**From:** Christopher Fraser <Christopher.Fraser@planning.nsw.gov.au>  
**Sent:** Monday, 31 May 2021 9:54 AM  
**To:** Grant Harlow  
**Subject:** S29/3/97-Mod-1 - Eastern Creek Karts, Departments design comments  
**Attachments:** Endeavour Energy.pdf

Following on from our discussions on design requirements on 26<sup>th</sup> and 28<sup>th</sup> May 2021 for the above please see the following notes for design work ;-

PLAN:
SHOWING CATENARY 1
AT SYDNEY PREMIERE KART PARK
BEING LOT 4 IN DP 1079897

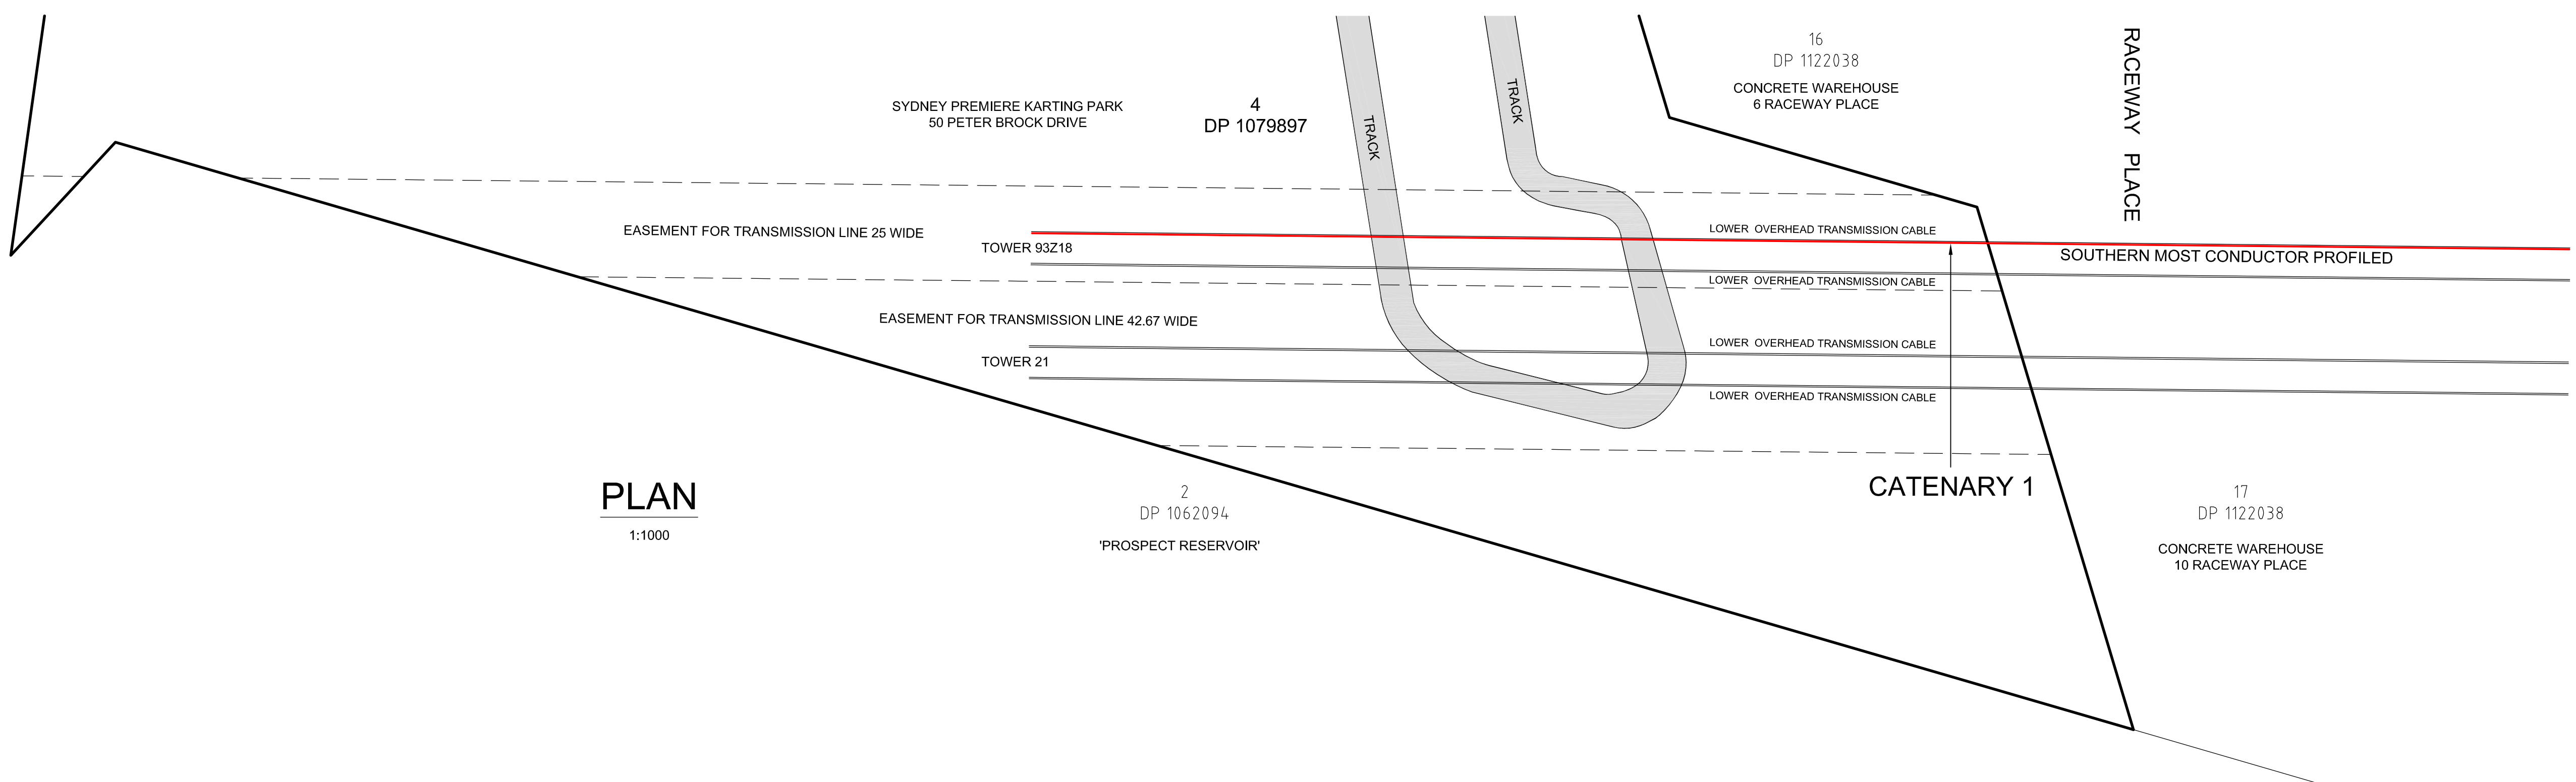
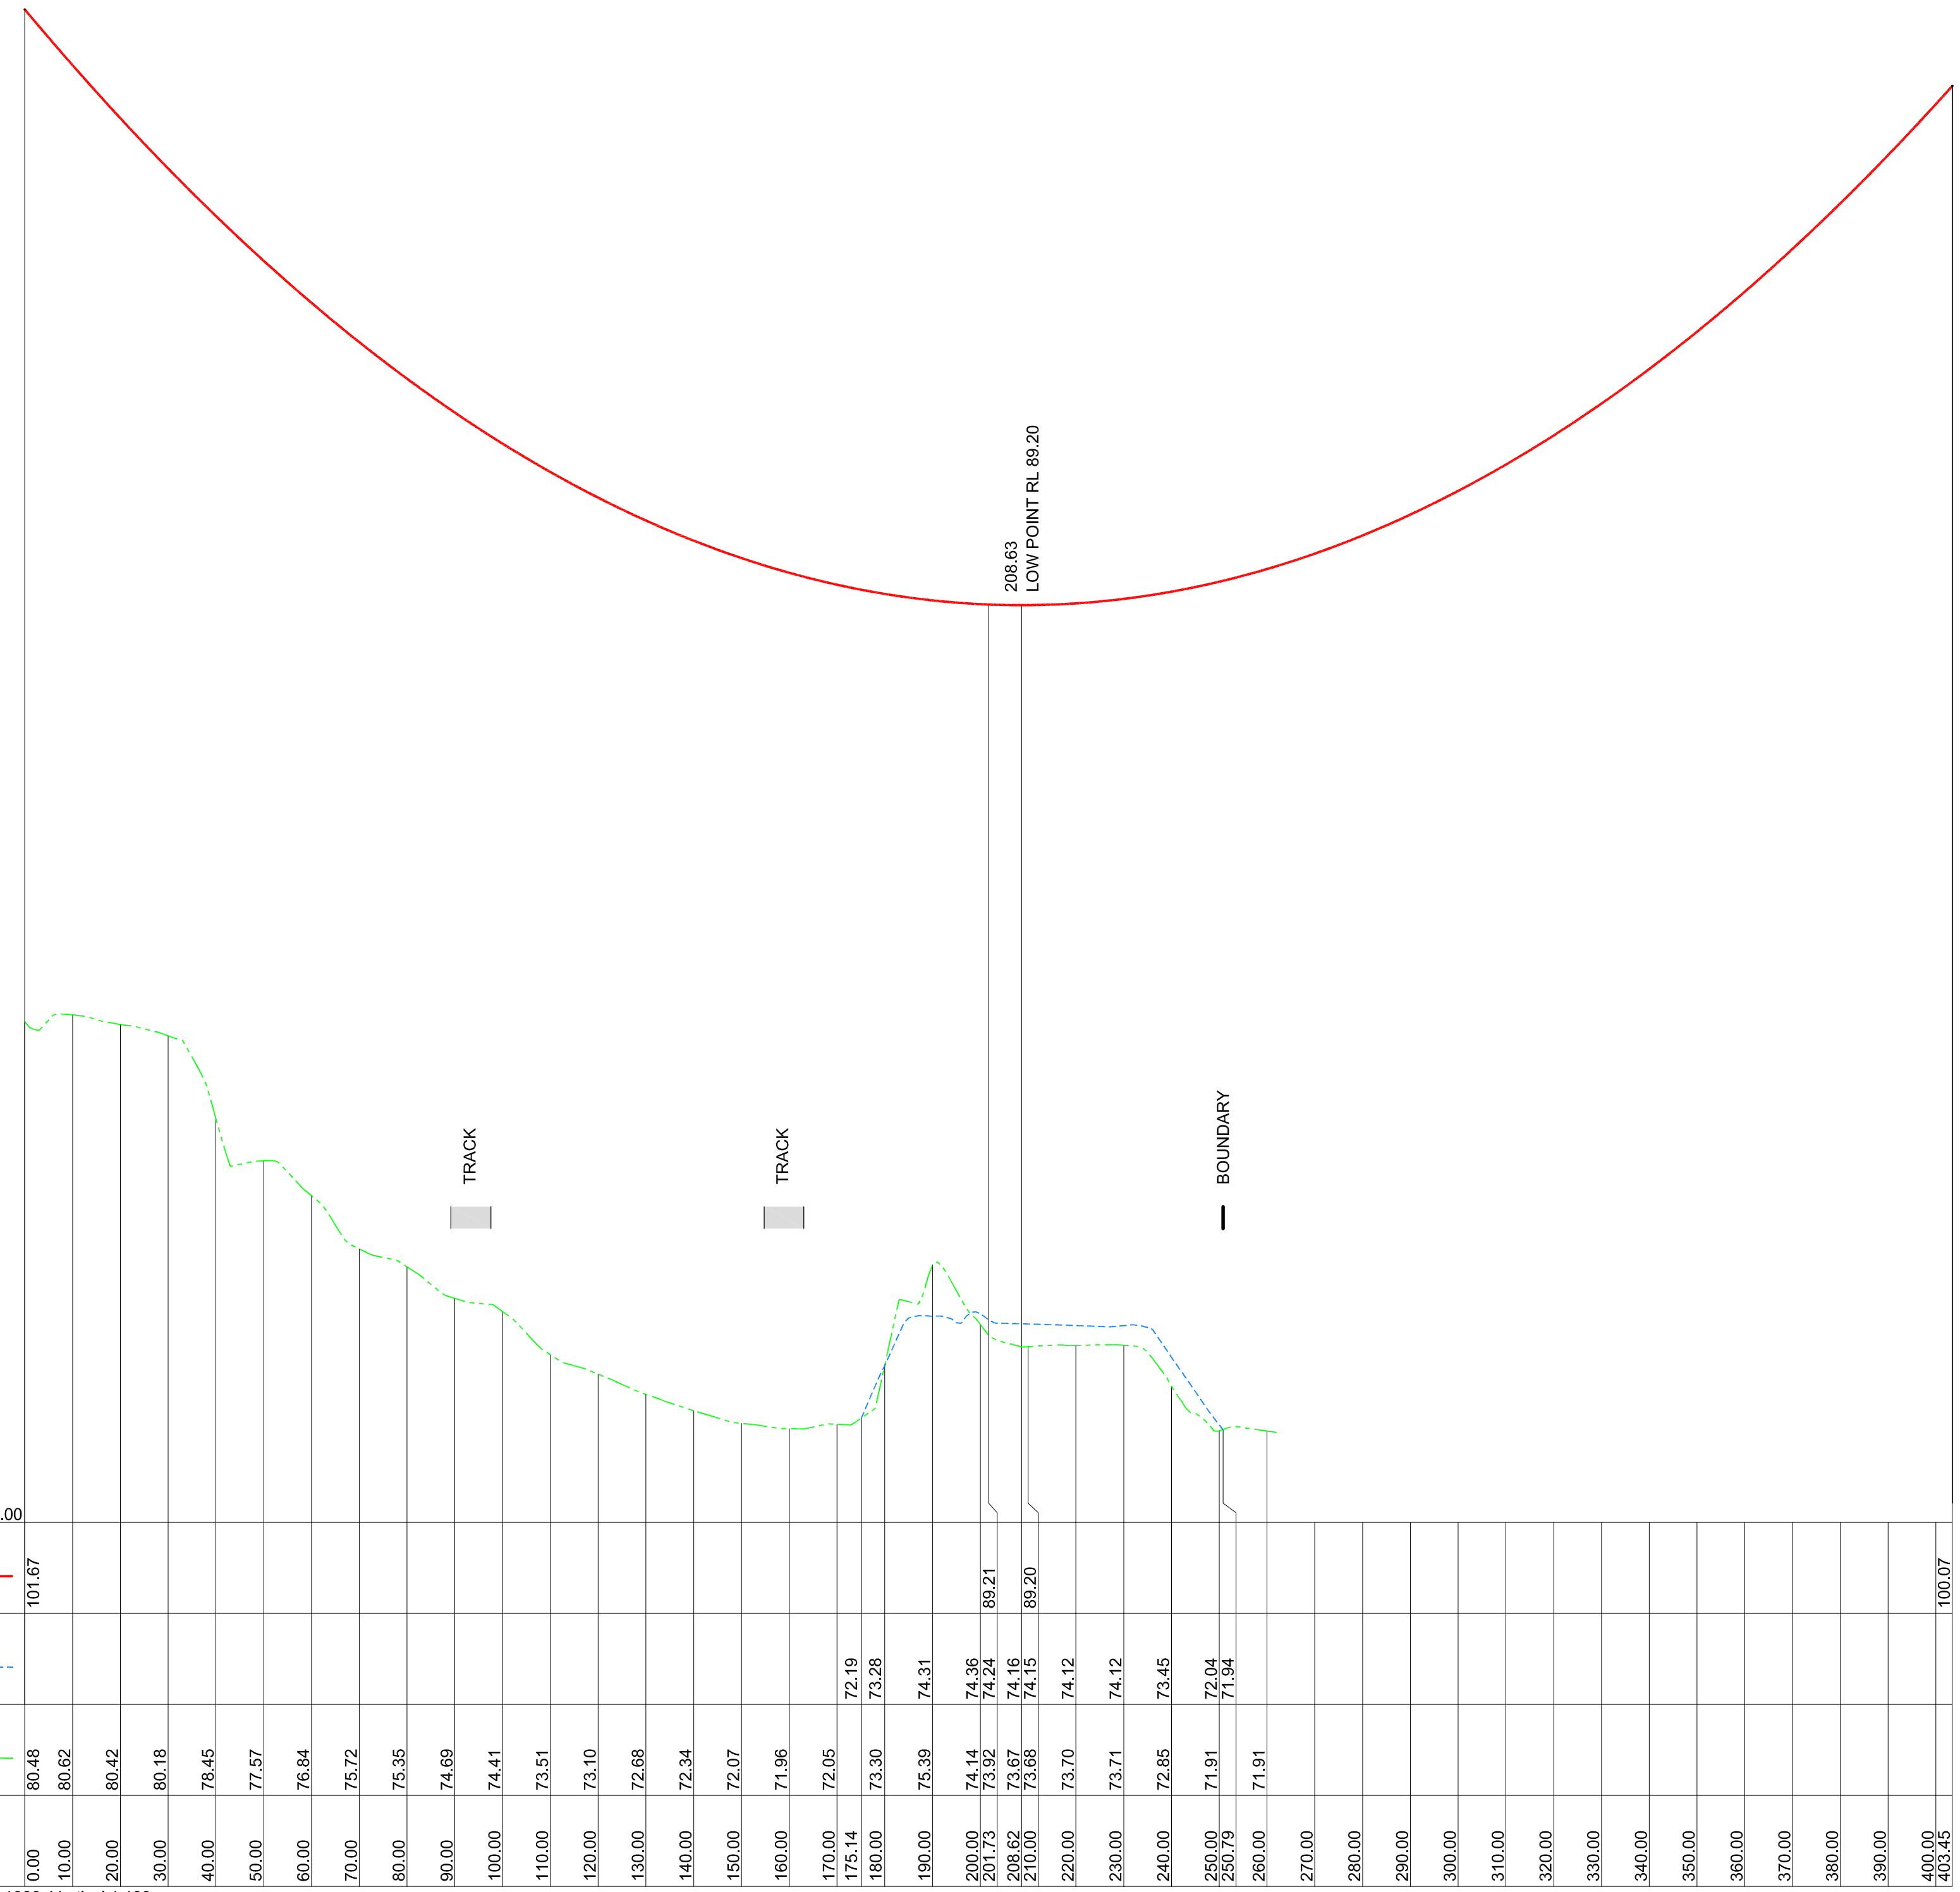
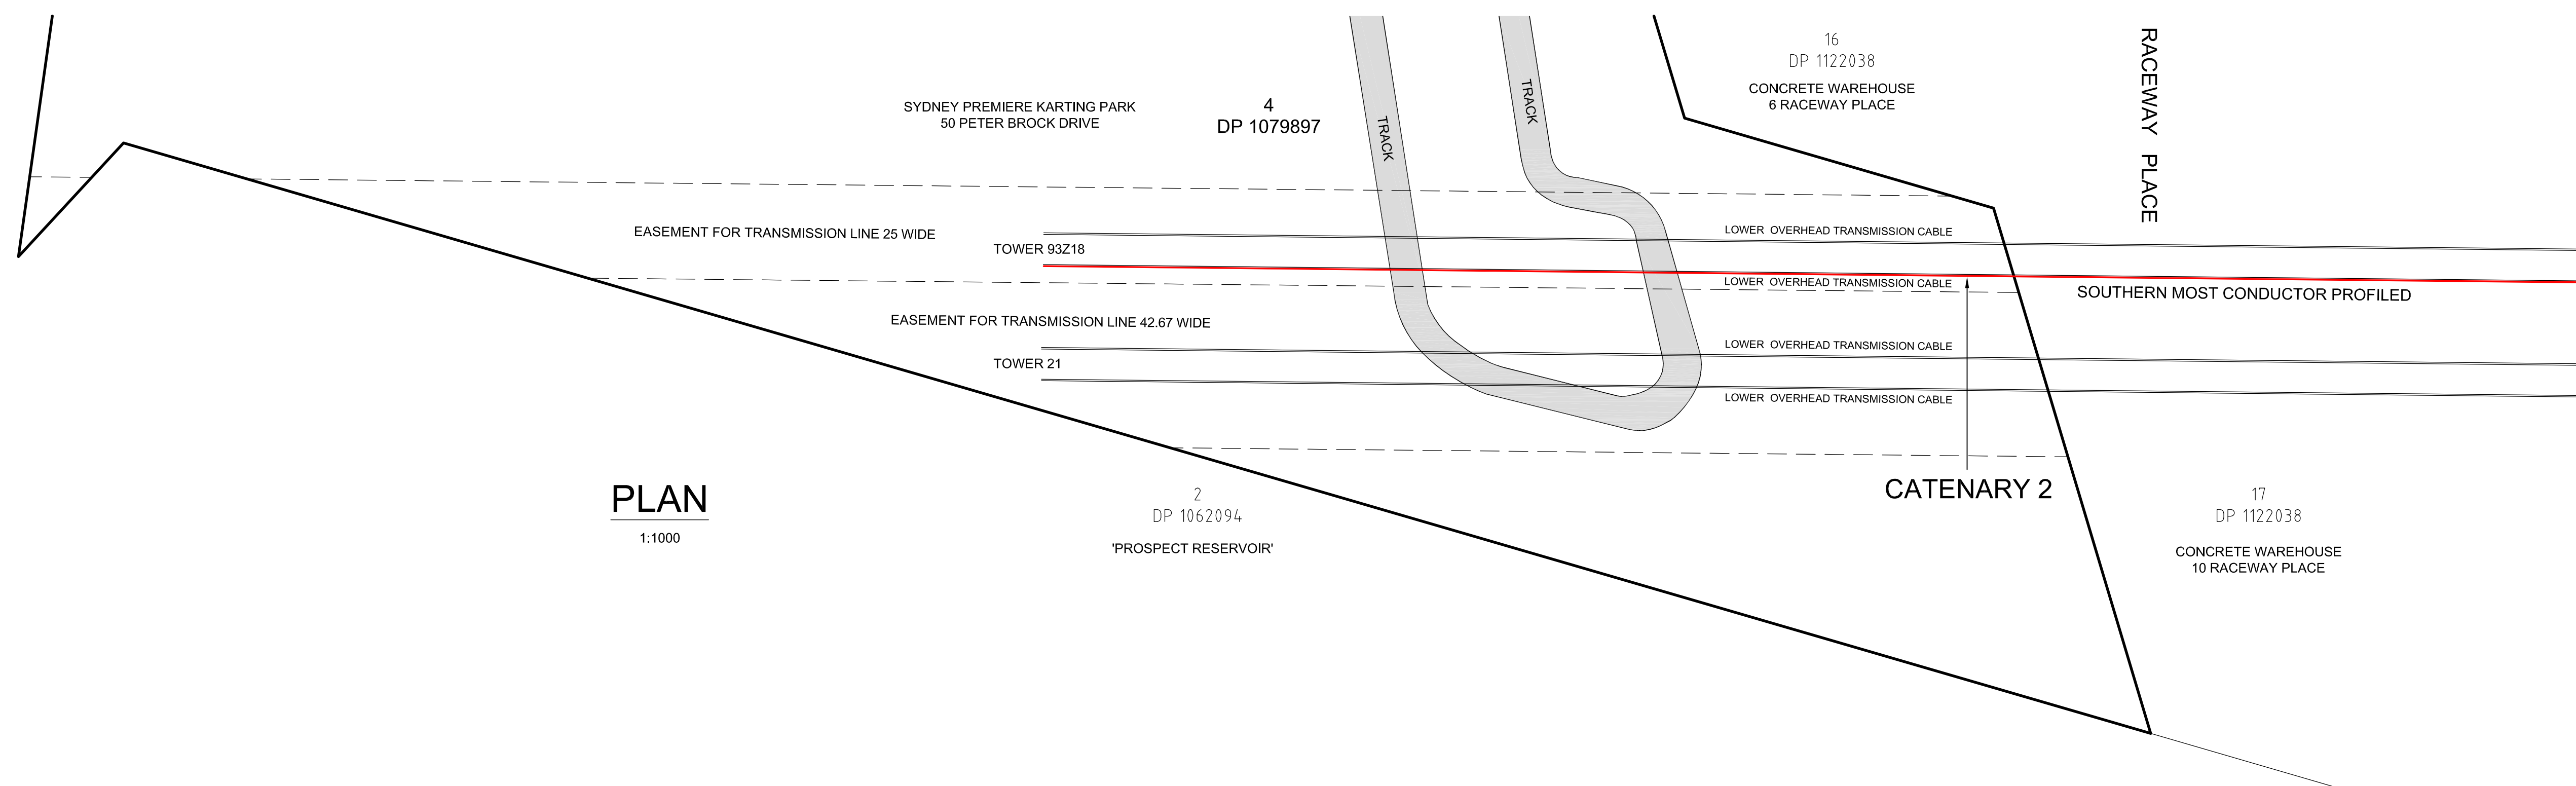
2. The vehicle's design height should be ascertained to ensure EE is satisfied with vehicle height, fill height, and consequent clearances to aerial conduits to prevent arcing.
